RE: 28 Winthrop St. - **POSTING NOTICE** CBL: 012 J006 Case Number: 2012-01-3157

## INSPECTION VIOLATIONS

<b>Owner</b> Harriet Moulton		<b>Code Enforcement Officer</b> George Froehlich	<b>Inspection Date</b> February 14, 2012
<b>Location</b> 28 Winthrop St.	<b>CBL</b> 012 J006	<b>Status</b> Open	<b>Case Number</b> 2012-01-3157

4 FOUNDATION PLAN  
1/4" = 1'-0"

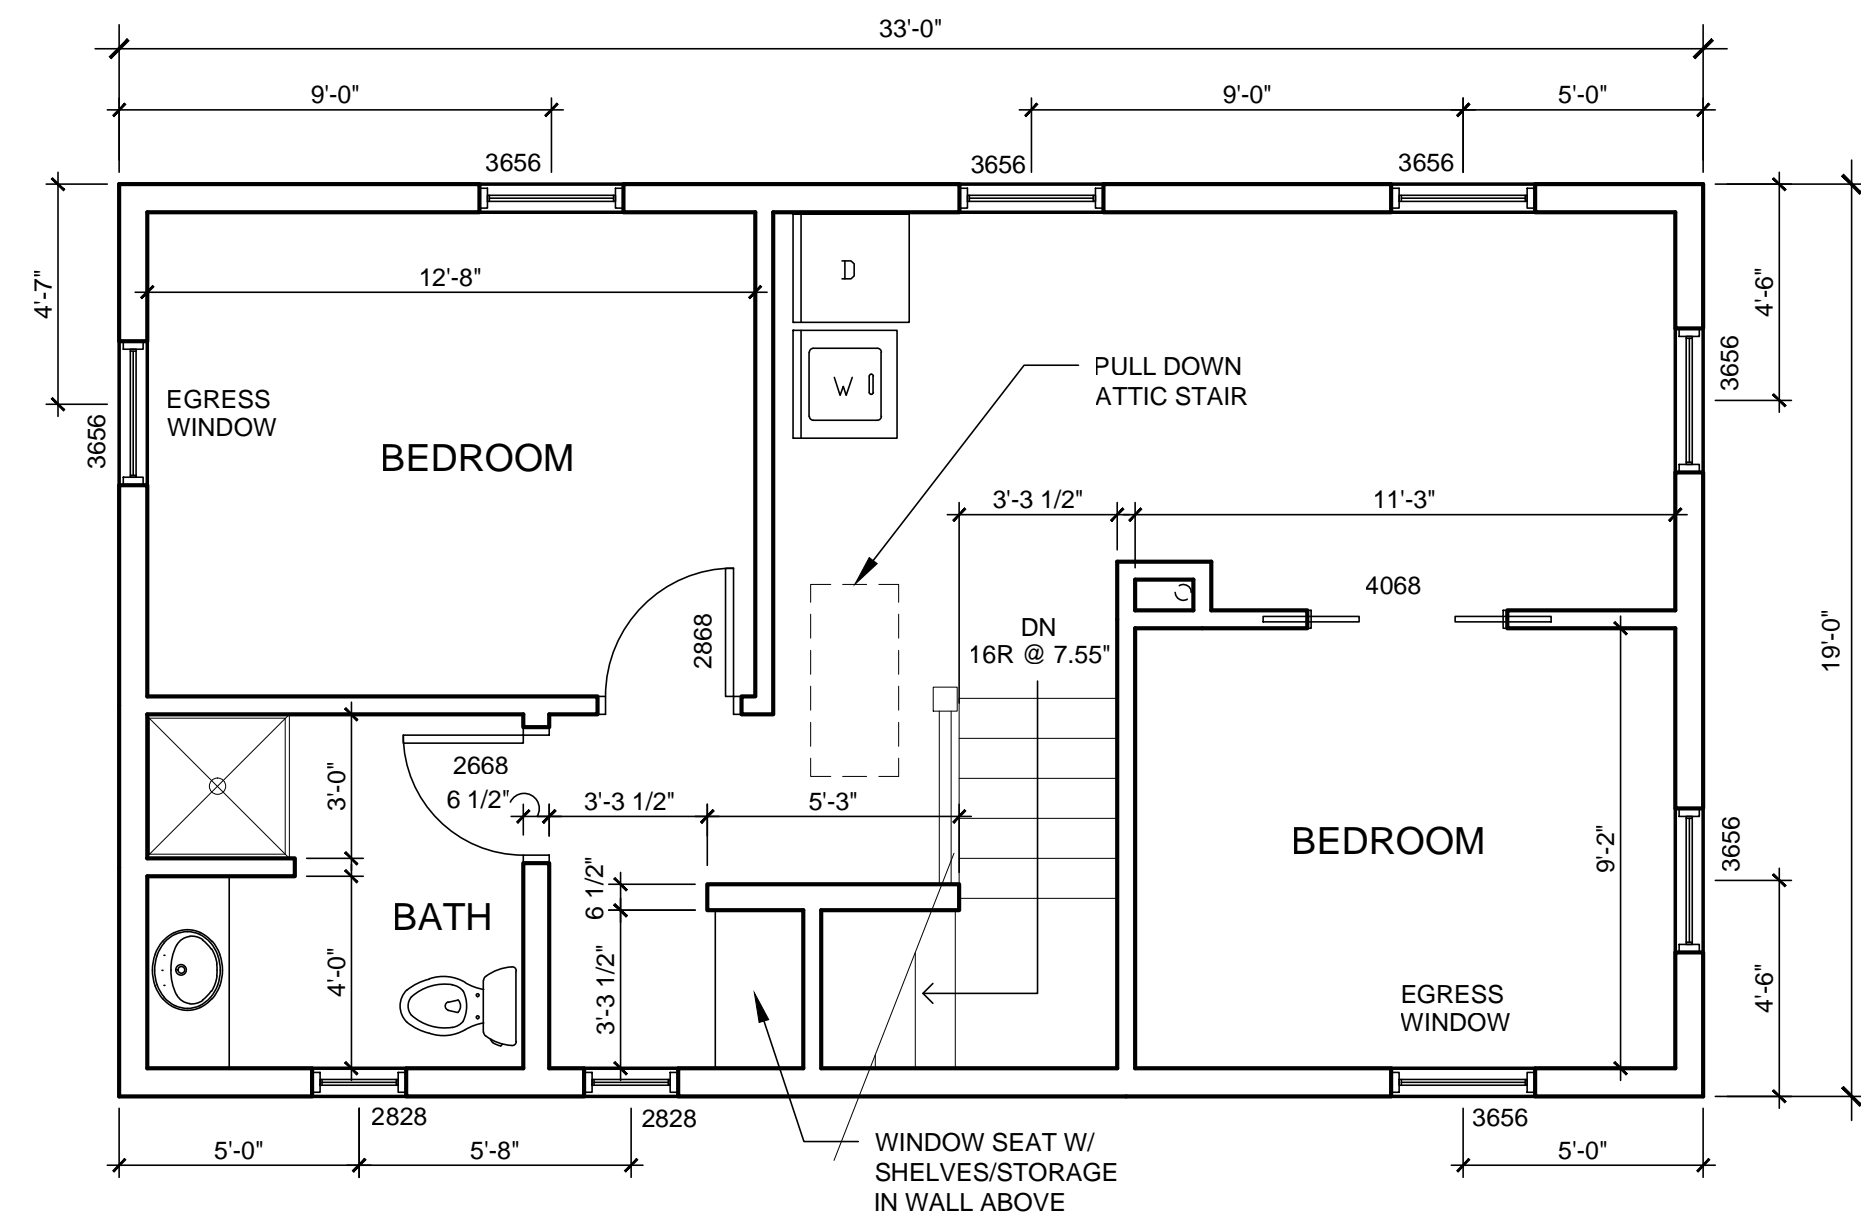
**Repair bowed foundation and exterior walls so they will support whatever load normal use may cause to be placed thereon, building permit required. (See attached engineering report).**

1 BASEMENT  
1/4" = 1'-0"

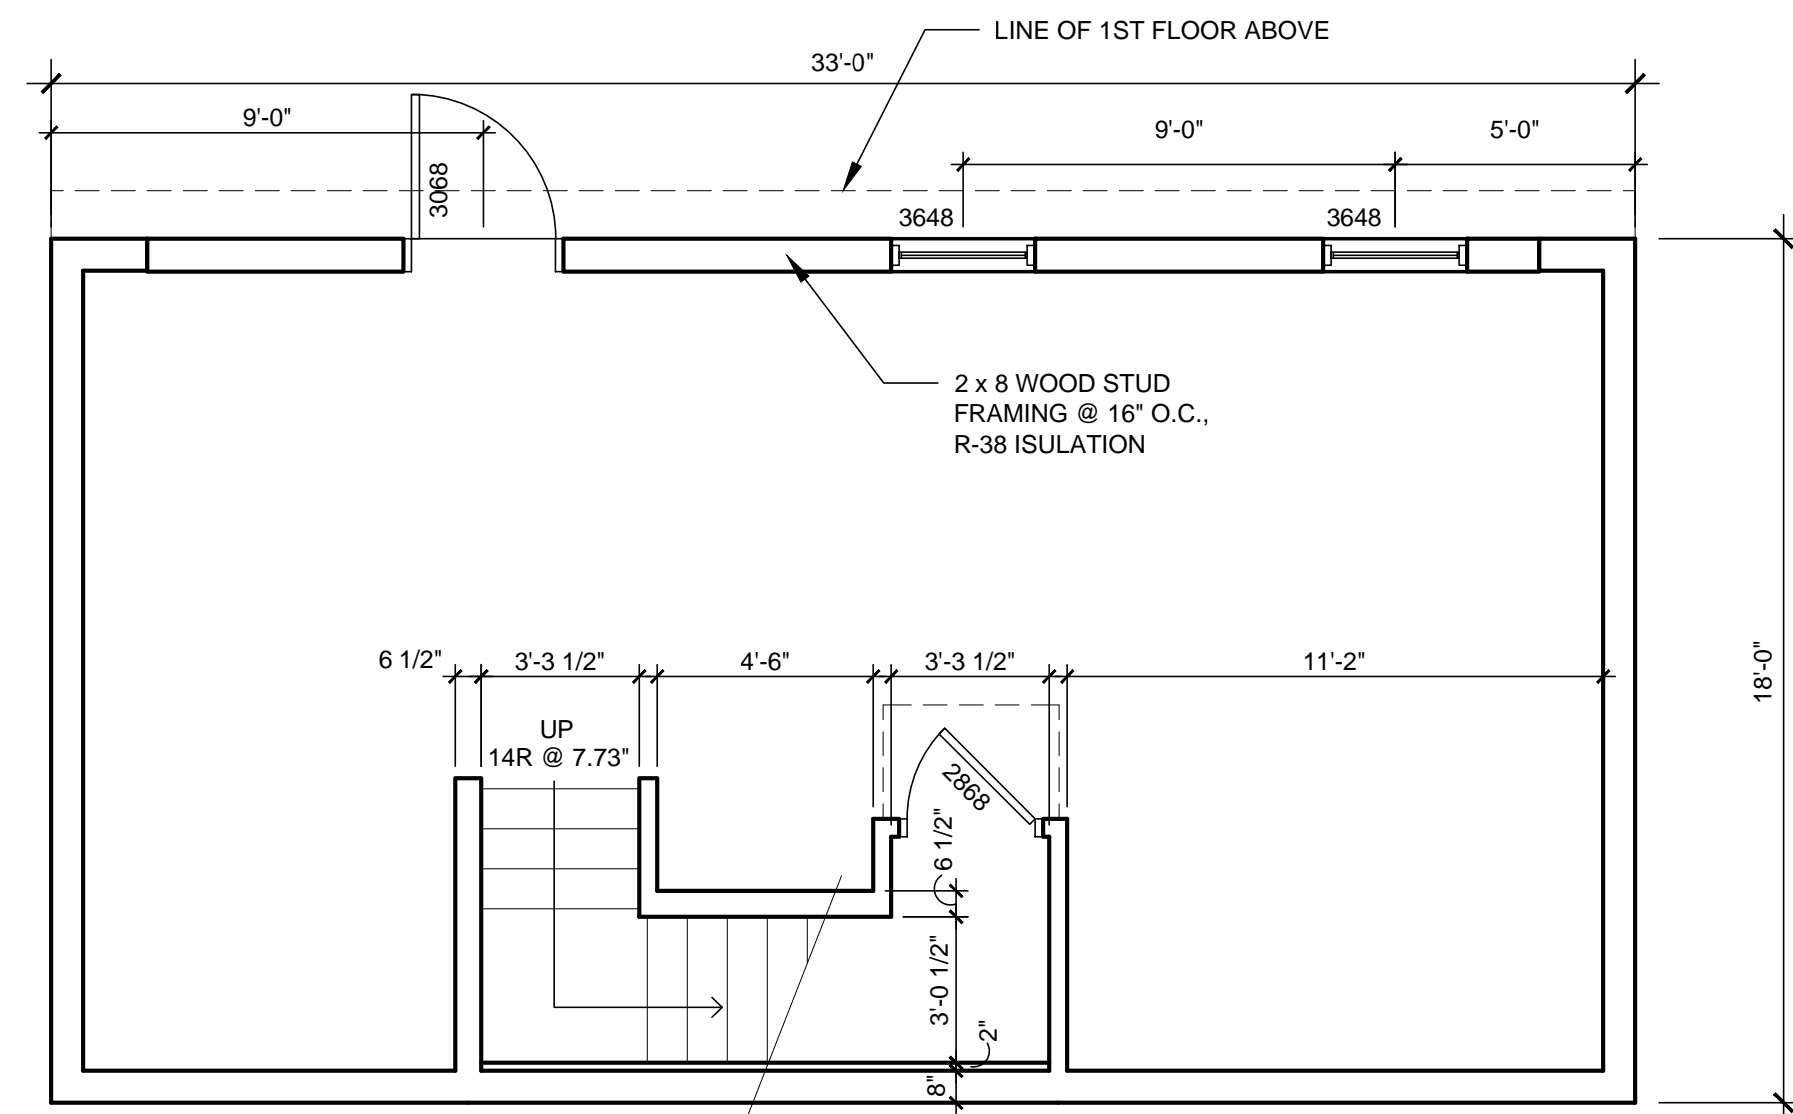
**Remove refuse and rubbish in basement.**

- STAIR DETAILS -

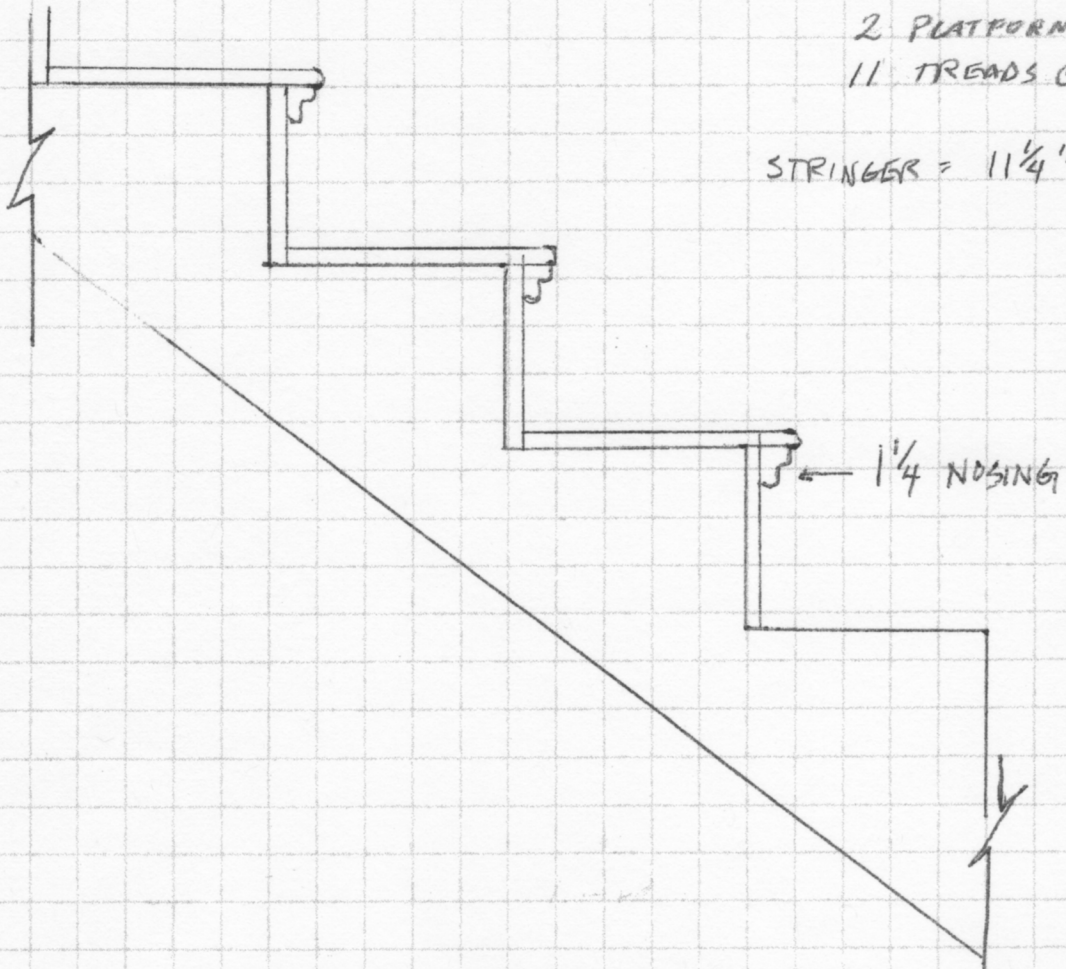
**Repair interior and exterior stairs and railings to make structurally sound, building permit required.**

2 DRIVEWAY ELEVATION
1/4" = 1'-0"

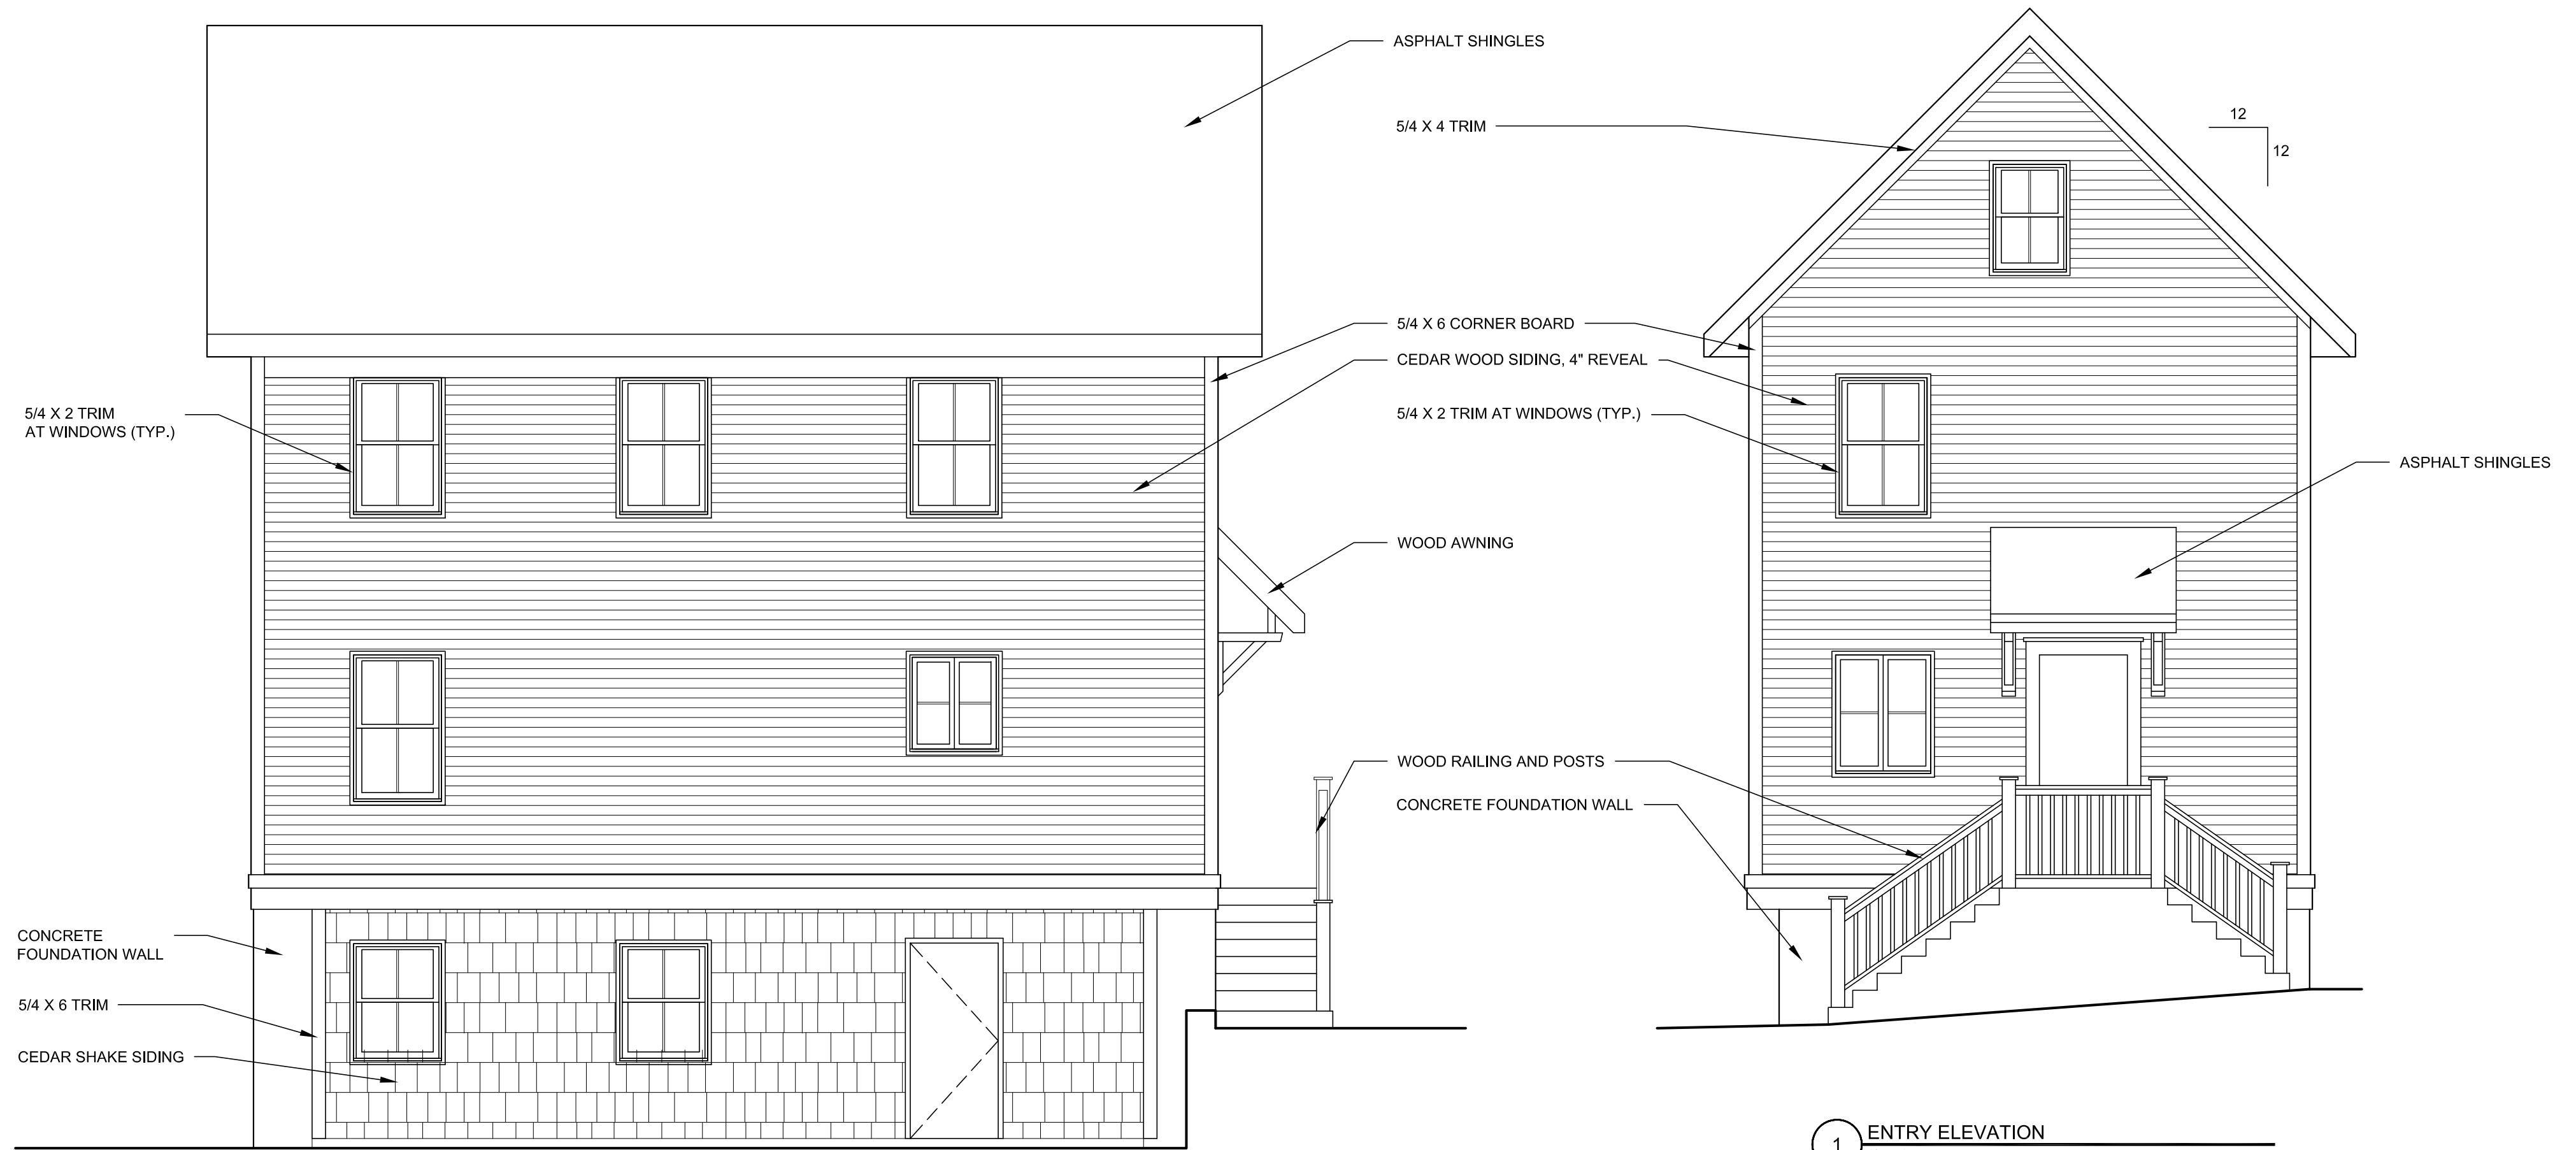
**Remove entry door on driveway side of house that is five feet above finished grade, building permit required.**
